Planning Application Ref: Y/82/20/RES

Location: Land to the south of Ford Lane and East of North End Road, Yapton, BN18 0DS

Description of works: Approval of reserved matters following outline consent Y/80/16/OUT for 4.5ha of residential development comprising of 3.4ha of land for the erection of 100 No. dwellings (up to 30 (30%) affordable housing) together with 1.1ha of land set aside for public open space, strategic landscaping, 2.2ha of public open space, green corridors with vehicular access from Ford Lane & pedestrian/cycle access only from North End Road (resubmission following Y/19/20/RES). This application may affect the setting of listed buildings, affects the character & appearance of the Church Lane, Yapton Conservation Area & affects a Public Right of Way. This site falls within Strategic Site SP2 (Zero Rated).

Mark Warwick
Tree Officer / Parks and Greenspace Team

Drawing Title Sections through Infiltration Basin

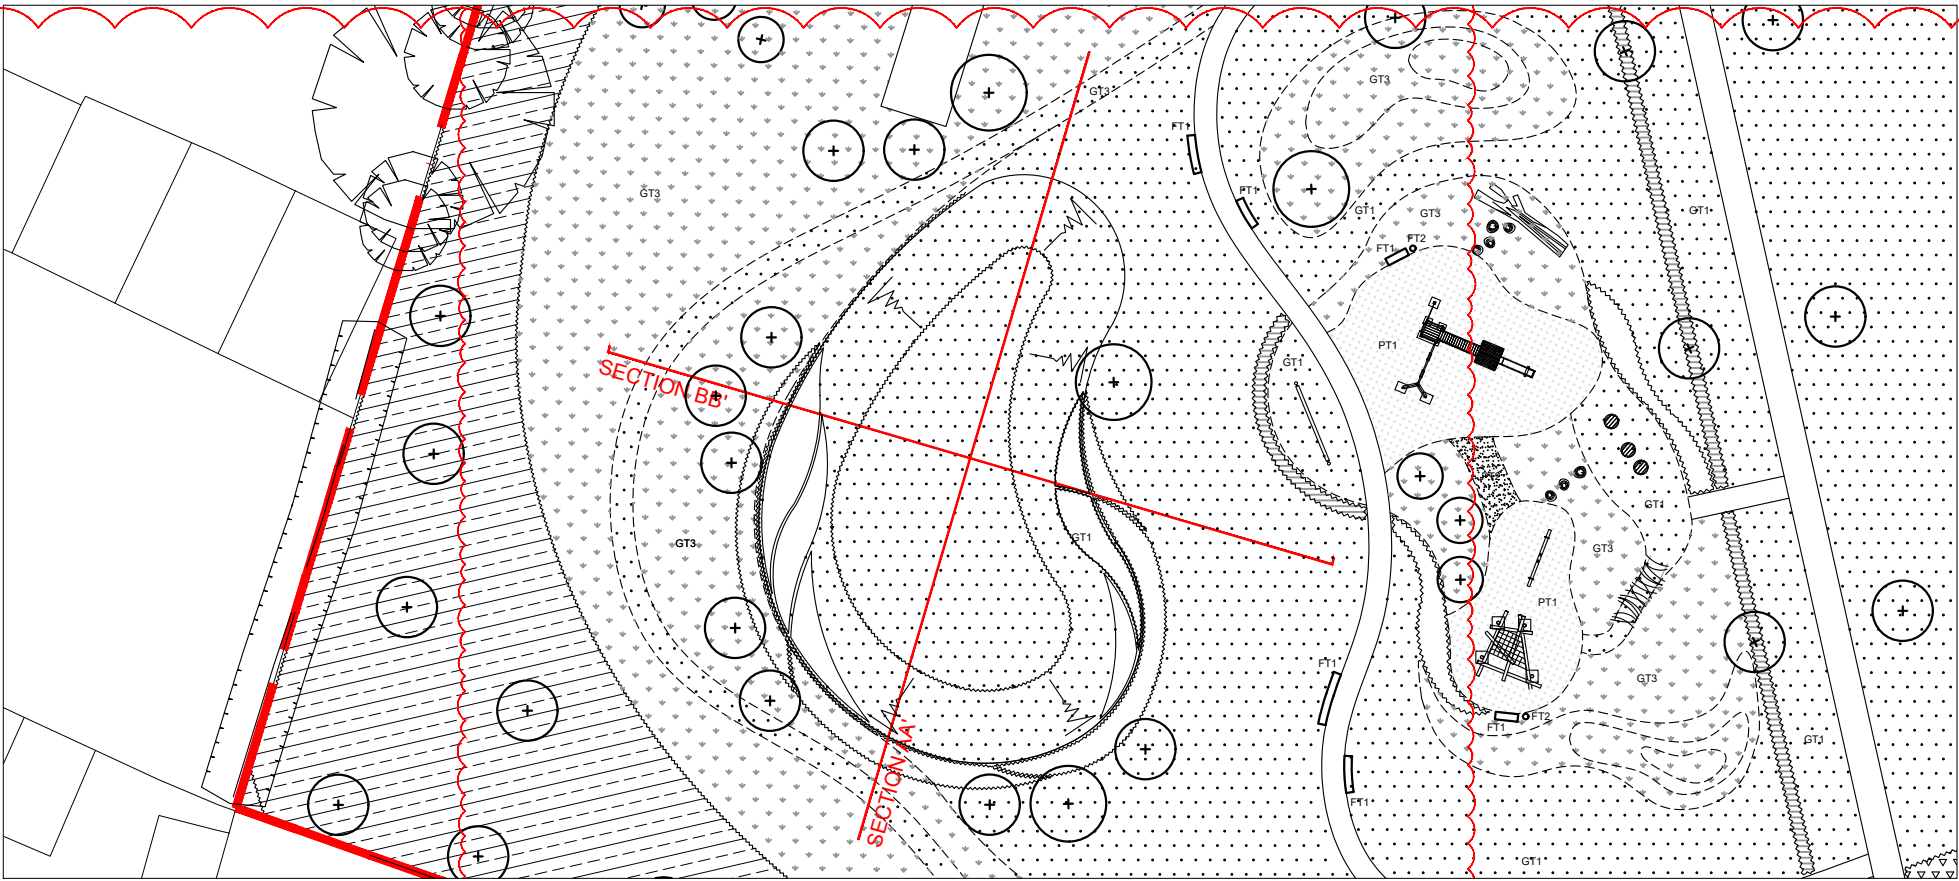
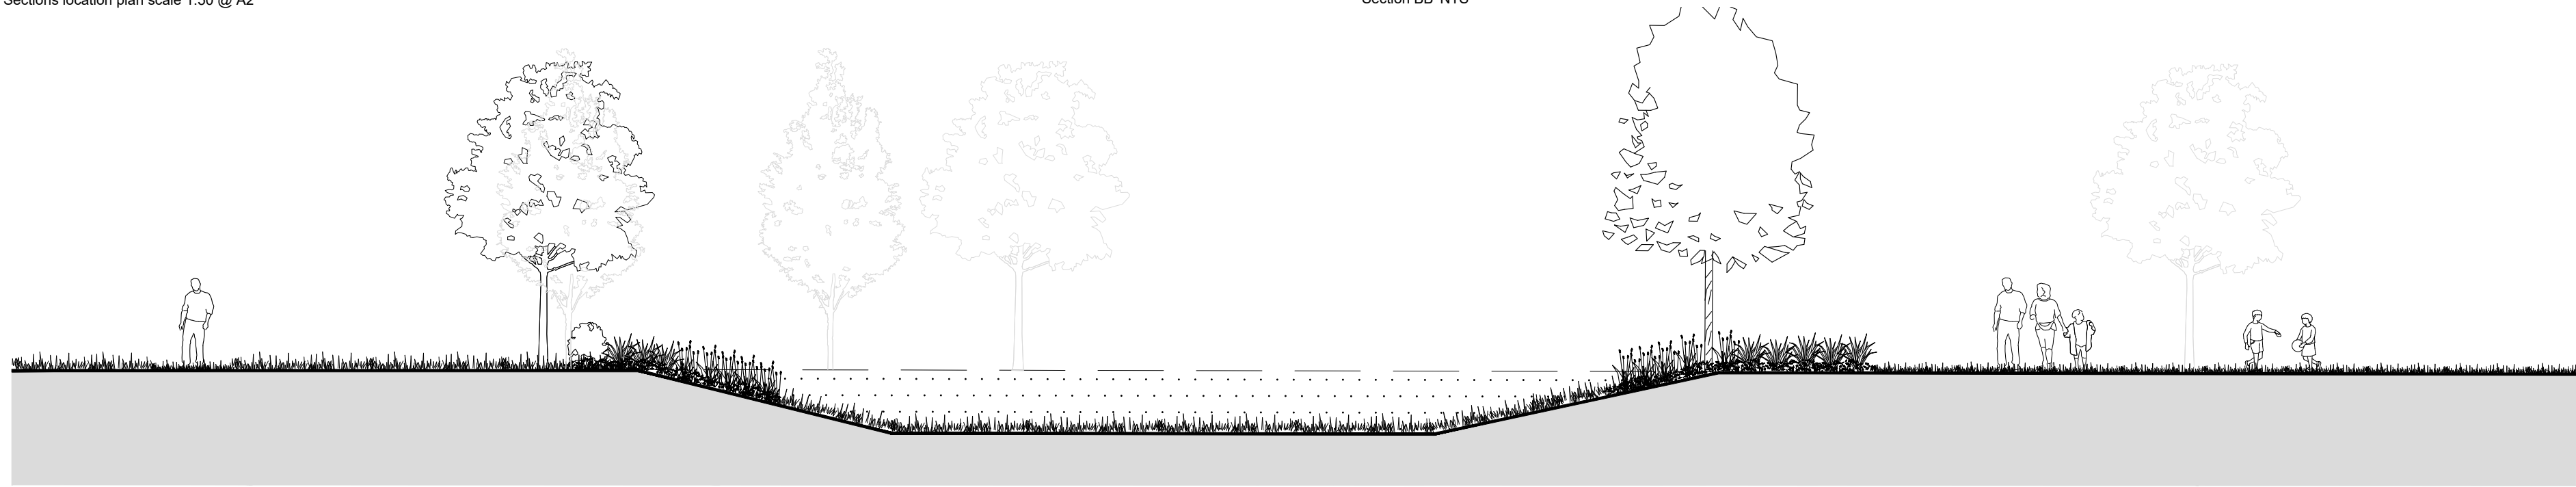
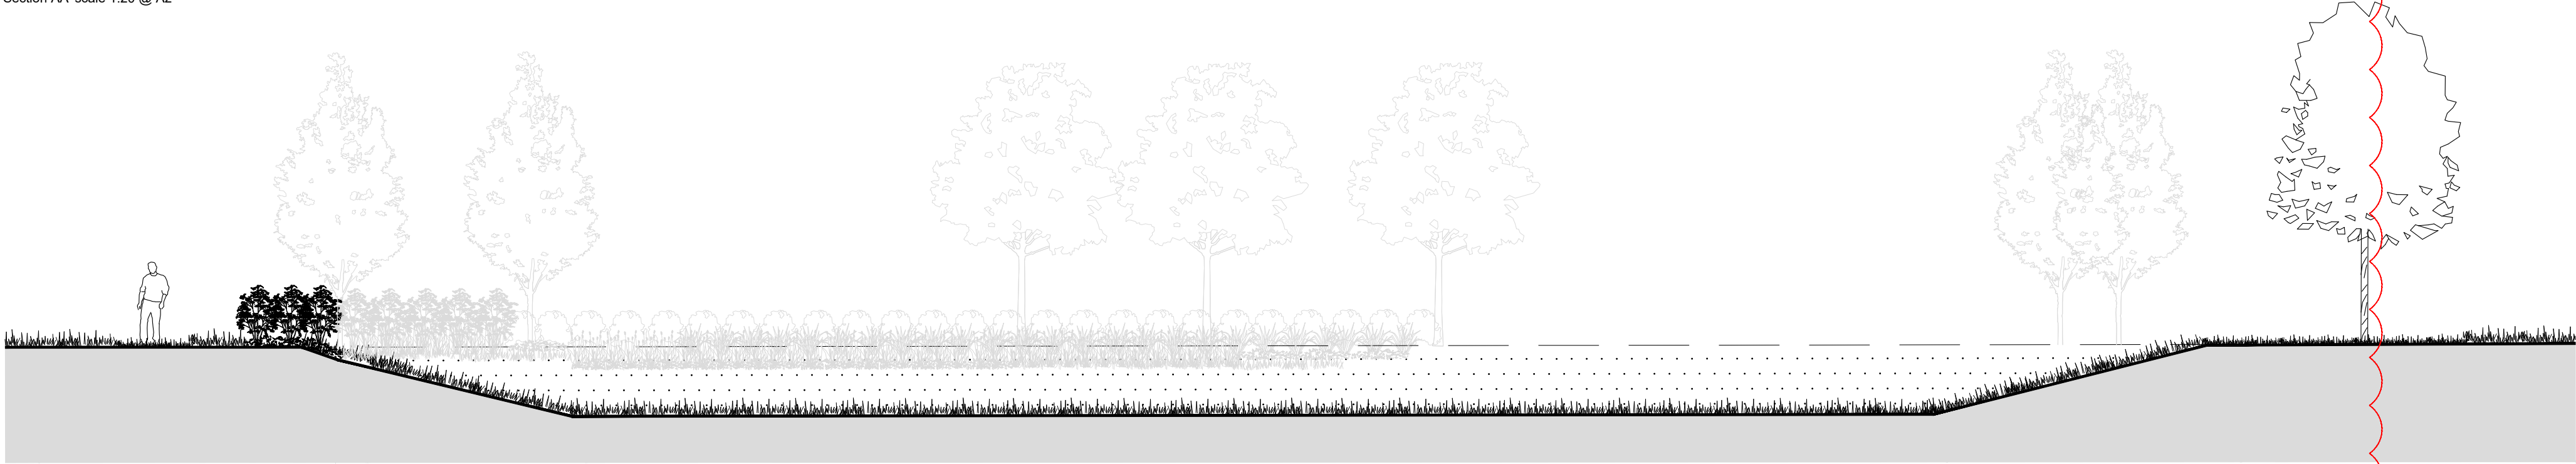
- **There appears to be a swale proposed to the east of the site (illustrated but not identified in any legend), which appears to intrude the root protection area of an important tree (opp. plot 29).** The siting of any SuDS feature without sufficient regard to existing and potential growth of retained trees is problematic and unlikely to gain the approval of Drainage Engineers. I urge revision of such a proposal and to allow for min. 3m easement outside of RPAs (plus 2m buffer zone) or to explore alternative locations within the site.
